Application no: H16-0917-09

Description: Erection of one pair of semi-detached dwellings

Location: 8 River Bank
Spalding
Lincs
PE11 3AA

Amendment: Amendments to extend landscaping, drains to low areas
of front gardens, trench drains, increase slope to gardens

Project
GOLDEN BALL PUBLIC HOUSE
Drawing Title
PROPOSED UPPER GROUND FLOOR

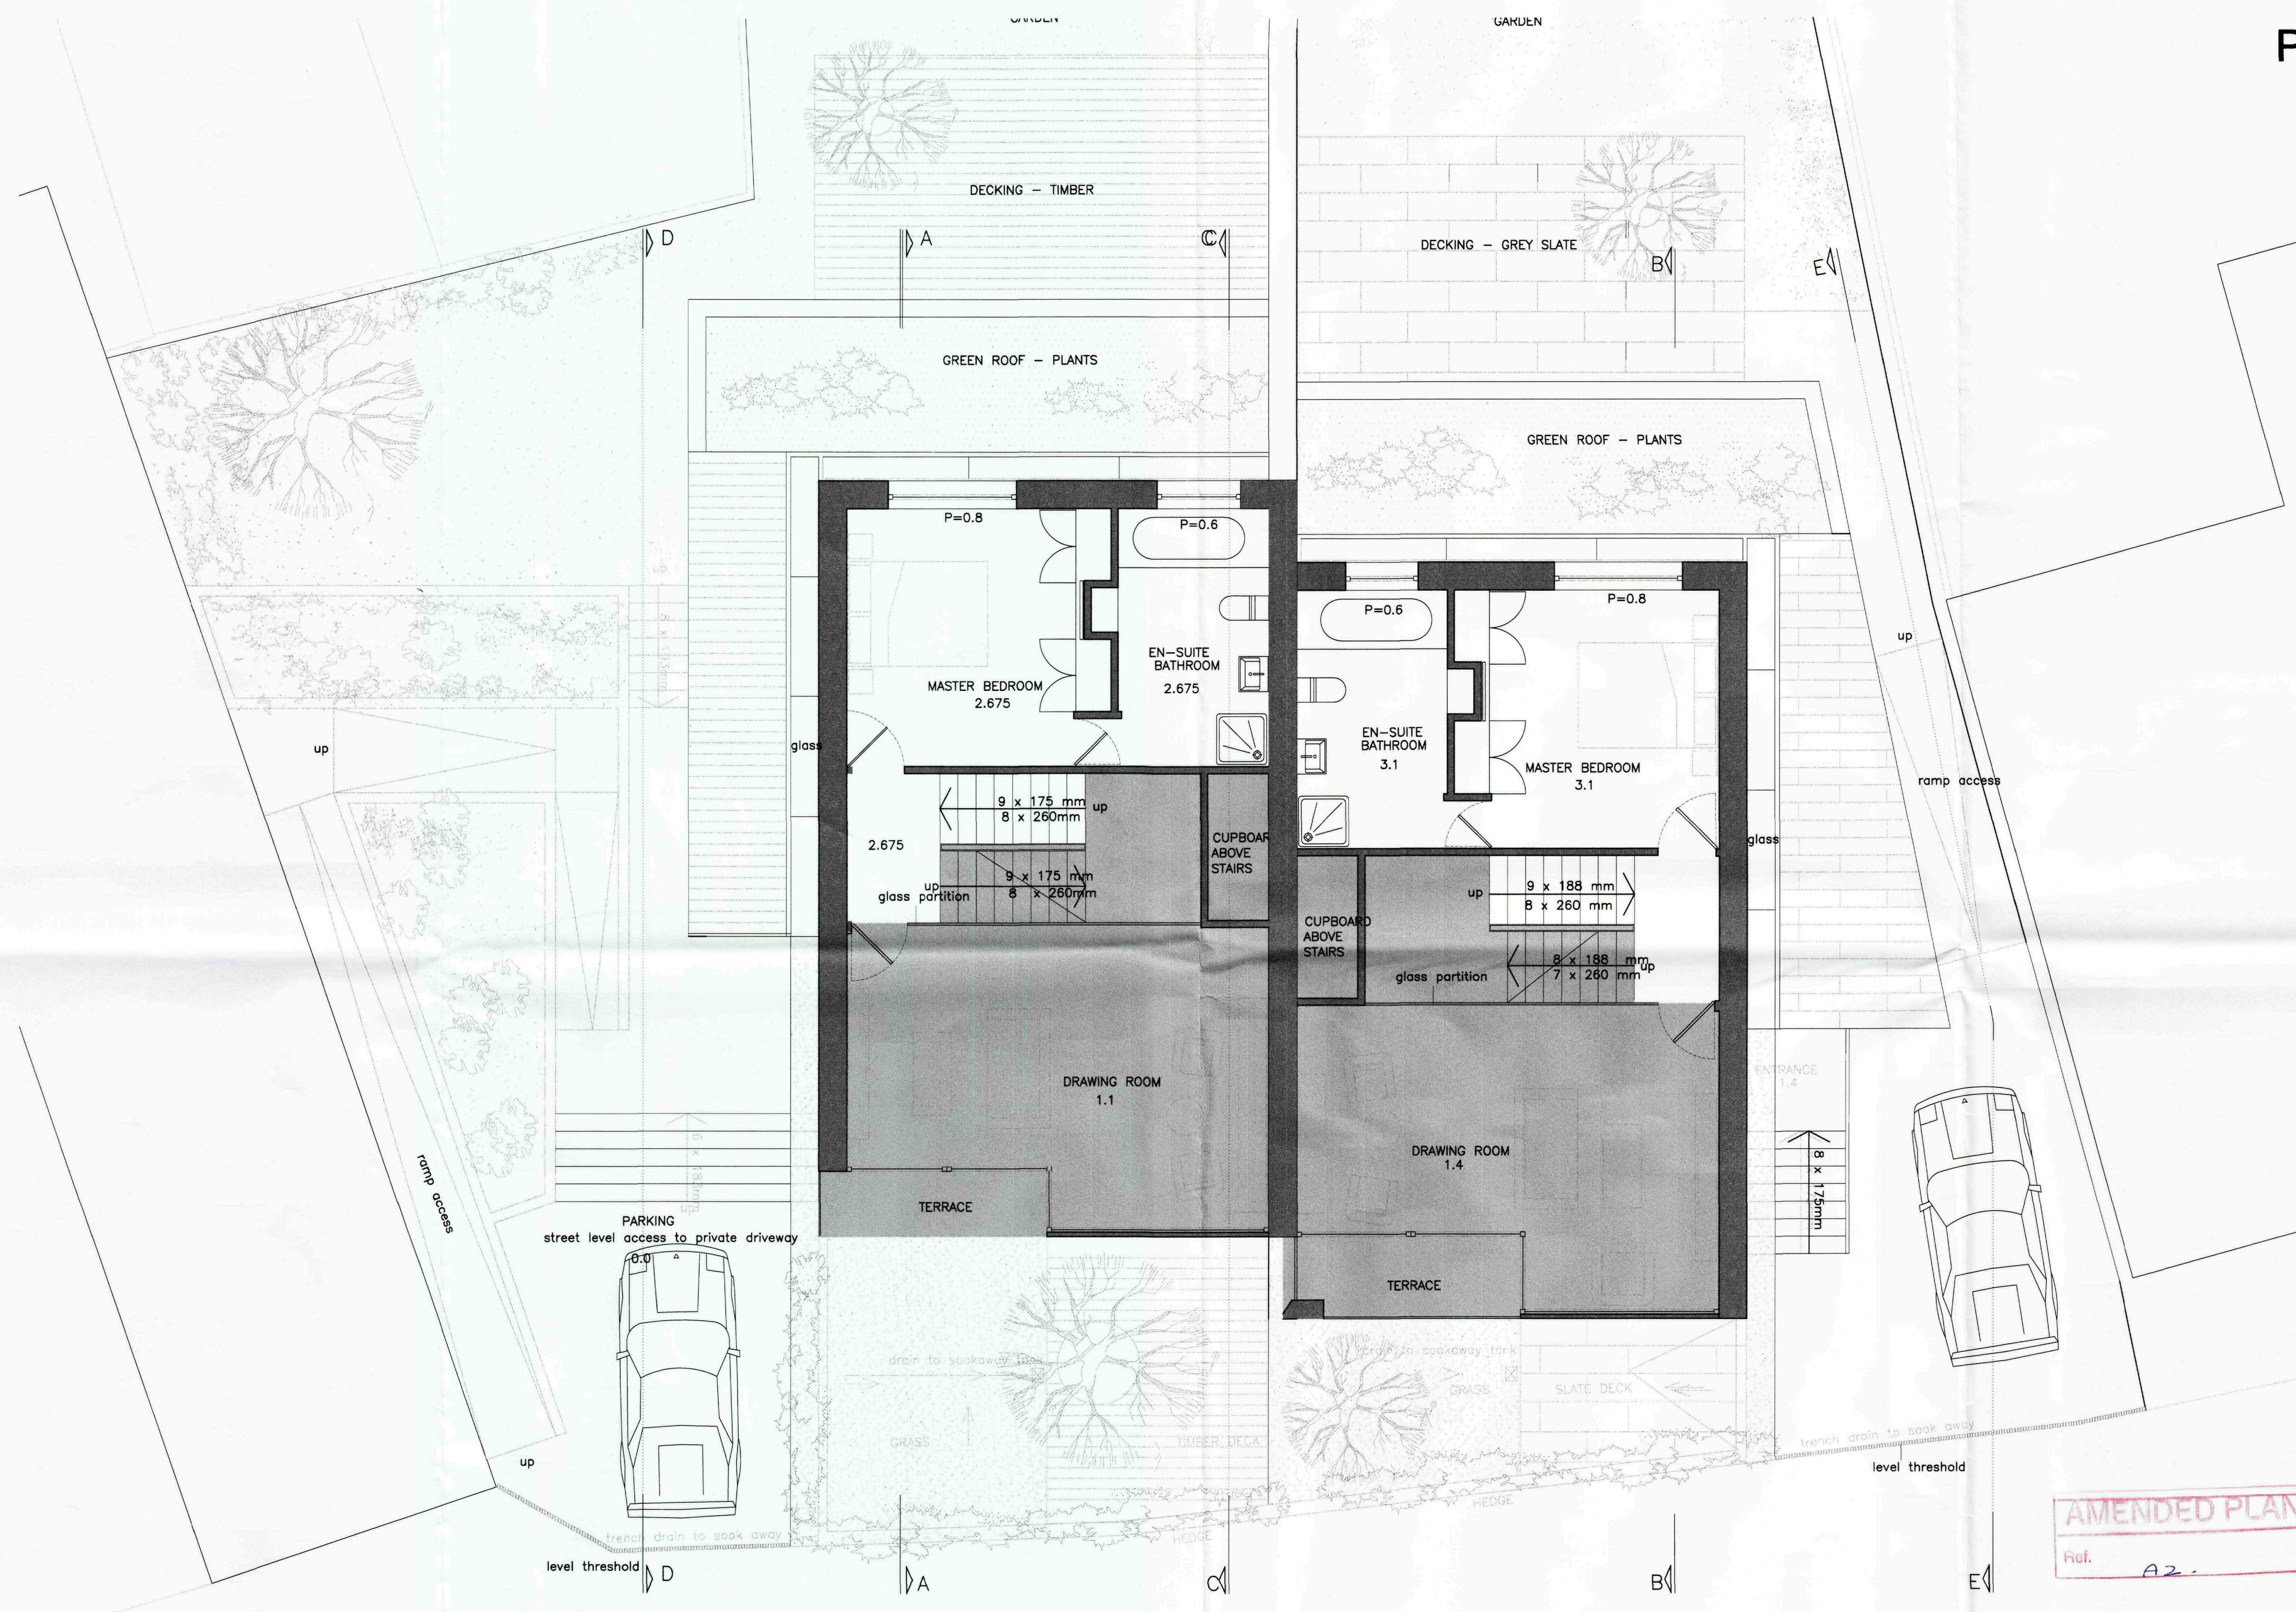
- A risk of pedestrians or drivers falling into what appears to be a sharp drop-off on the edge of the front

garden of the slate faced building

- The same sharp drop-off providing no lateral support to the structure of the adjacent highway
- The low area between the front of both buildings and the edge of the highway becoming a sump for any surface water running off the highway (and from within the curtilage of the plot) thereby causing a nuisance to future occupiers of the dwellings.

- extending what appears on your drawing to be a hedge across the full frontage the garden of the slate faced building may help avoid pedestrians and drivers from straying over the edge
- retaining the sloped batter (rather than creating a vertical face) at the edge of the carriageway would avoid compromising the structural integrity of the highway (and at the same time remove the hazard of the drop-off)
- improving the ability of the ground between the buildings and the highway to absorb any surface water run-off may reduce the likelihood of standing water within the front gardens of the properties

1. We have omitted a sharp drop at 'road to front gardens' boundary by increasing the slope of the front garden decking/landscaping that now meets the edge of the road. This amendment will provide the lateral support to the structure of the road and will prevent the hazard of the drop-off.

2. We have improved the ability of the front gardens ground areas to absorb surface water by leaving half of the area as soft landscaping – This is in addition to retaining the trees and hedges that are already proposed.

3. We have extended the hedge across the full frontage of the front gardens in order to demarcate the edge between public highway and sloped front gardens.

4. We have added a drain to the low areas of front gardens, which will be linked to a soakaway in rear gardens.
5. We have added a trench drain between proposed driveways and adjoining road so that existing road drainage is not affected by the proposed development.
